Our Ref: TR/11146/jj

31 July, 2019

**RE: QANTAS FLIGHT TRAINING CENTRE (SSD 10154)**  
**RESPONSE TO TRAFFIC MATTERS RAISED IN SUBMISSIONS**

1 SITE - PROPOSED
1 : 500

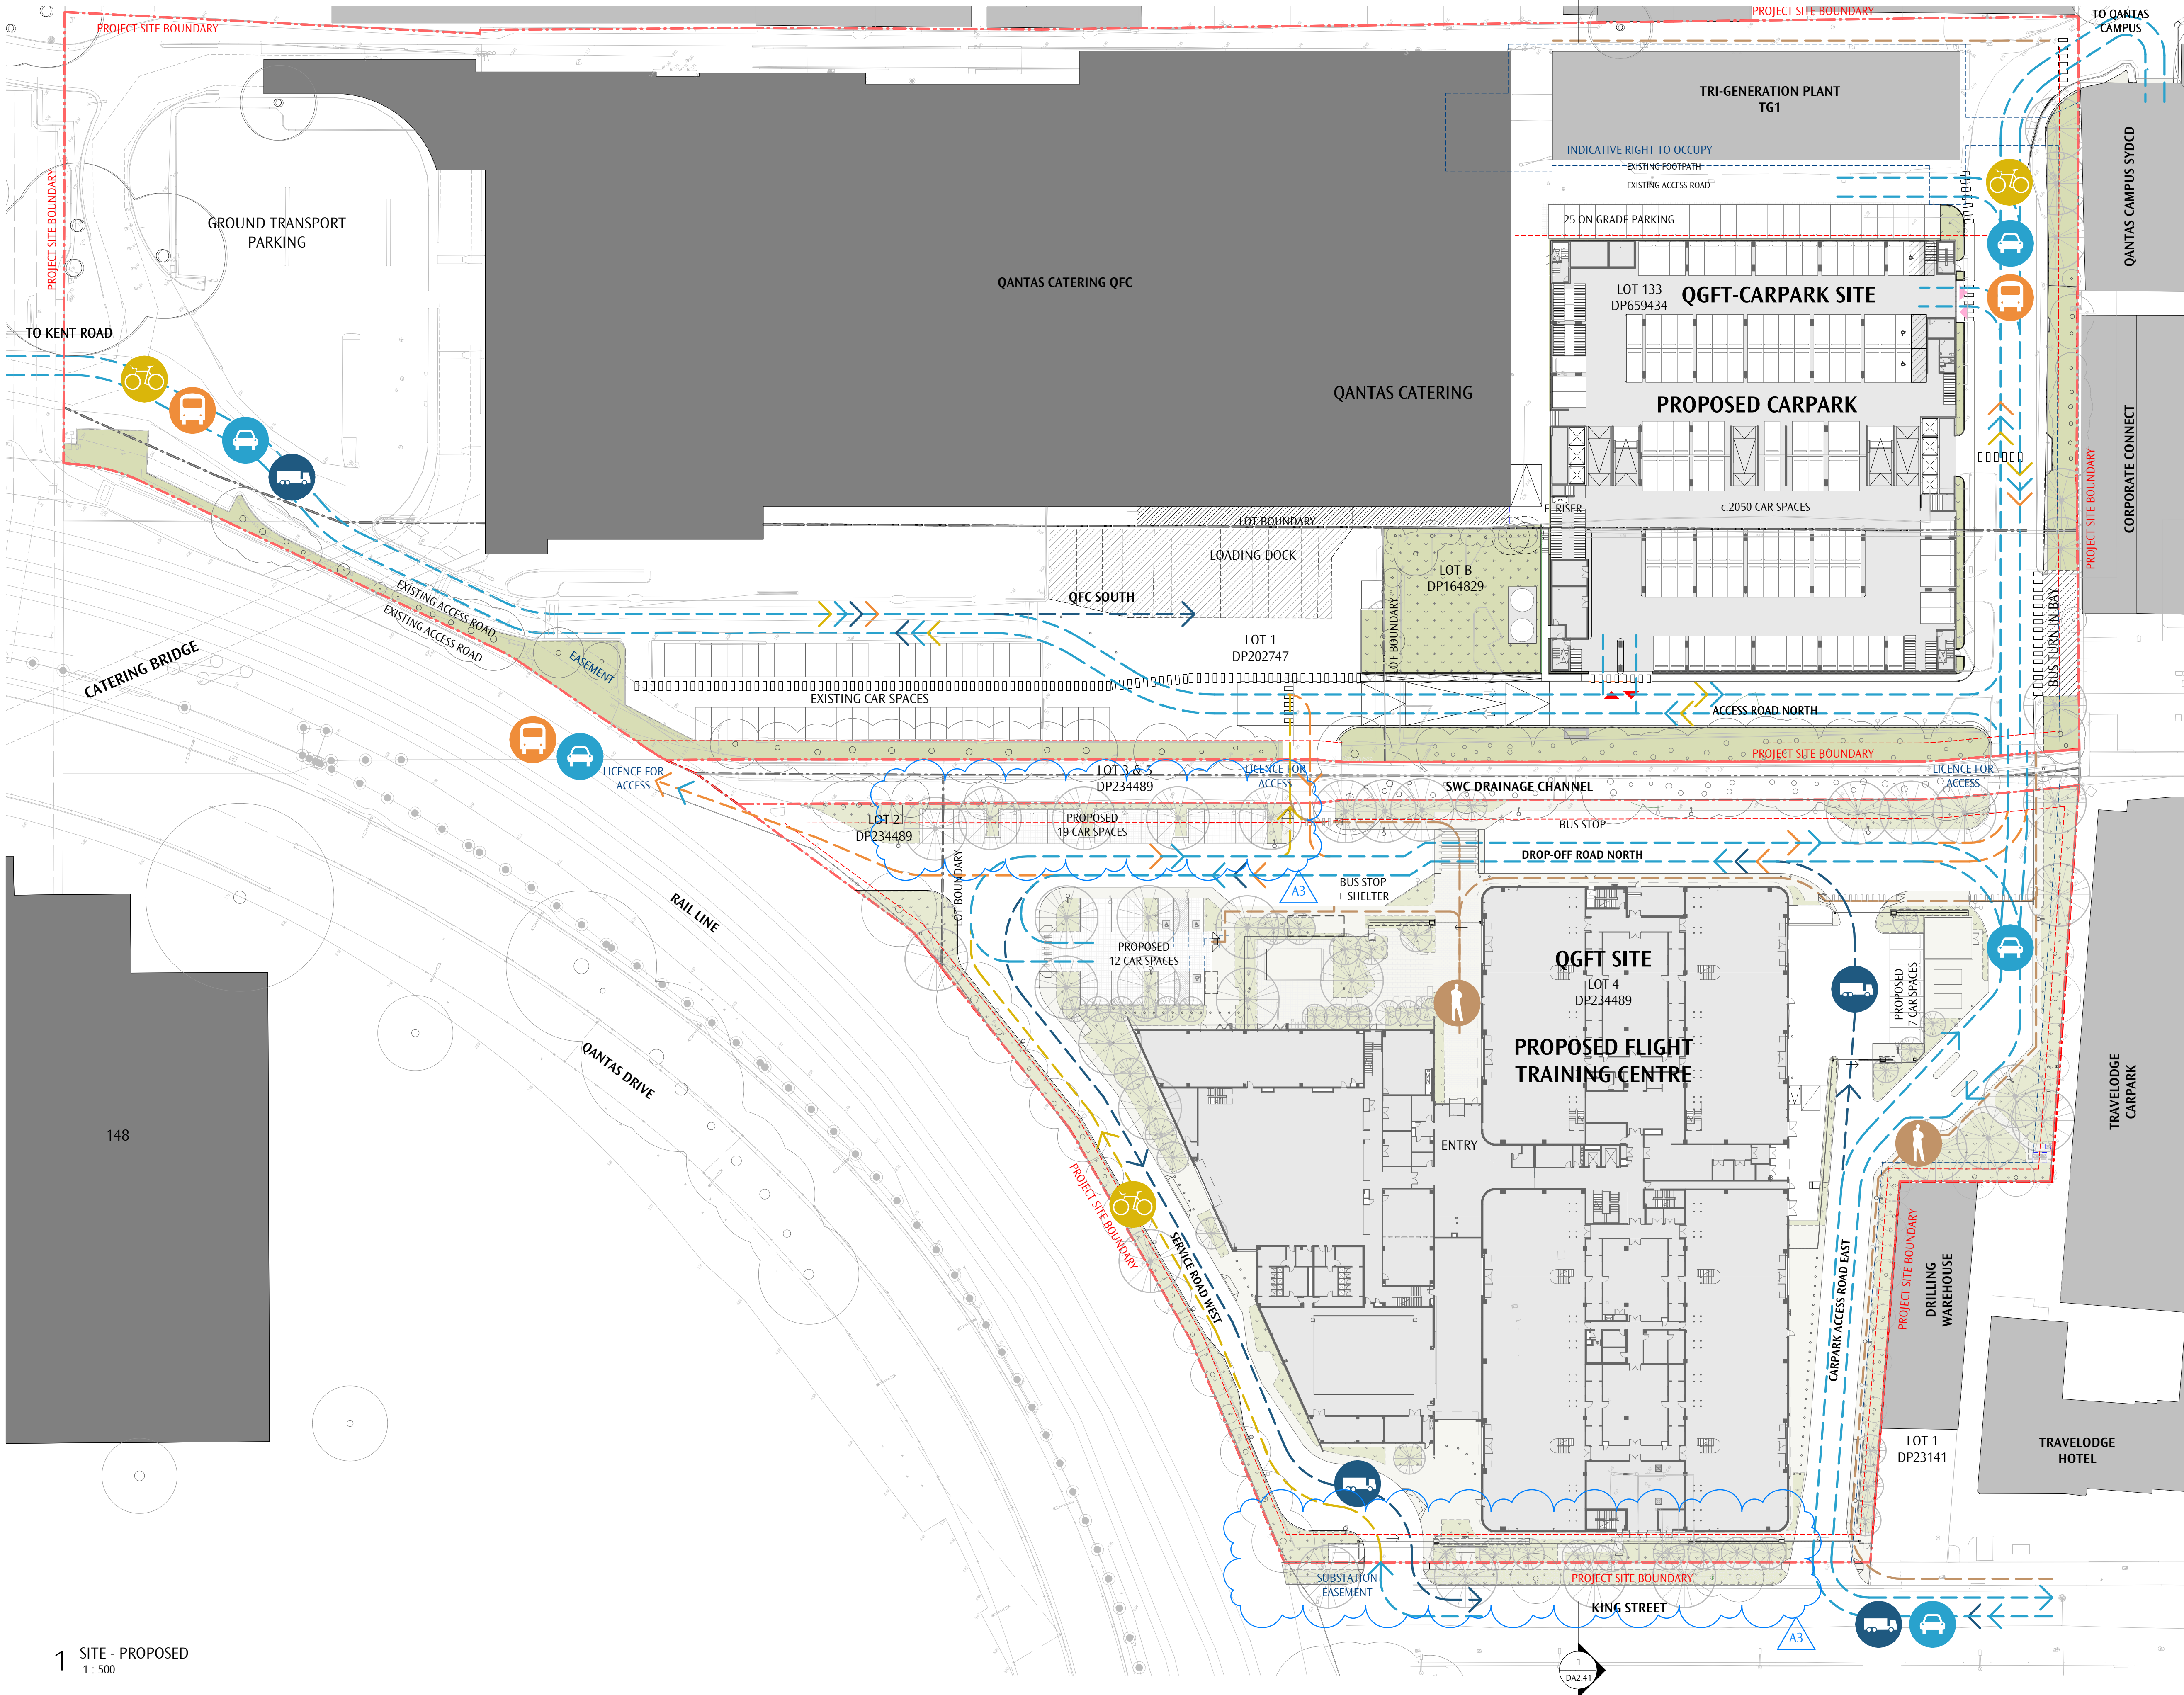
- *further information on how the loss of existing parking will be managed during construction; and*
- *provision of a plan showing new and existing internal service roads that are consistent with the commentary provided the traffic report.*

12. Figure 5 in the traffic report shows access to and within the site via new and existing access roads. A copy of Figure 5 is attached.
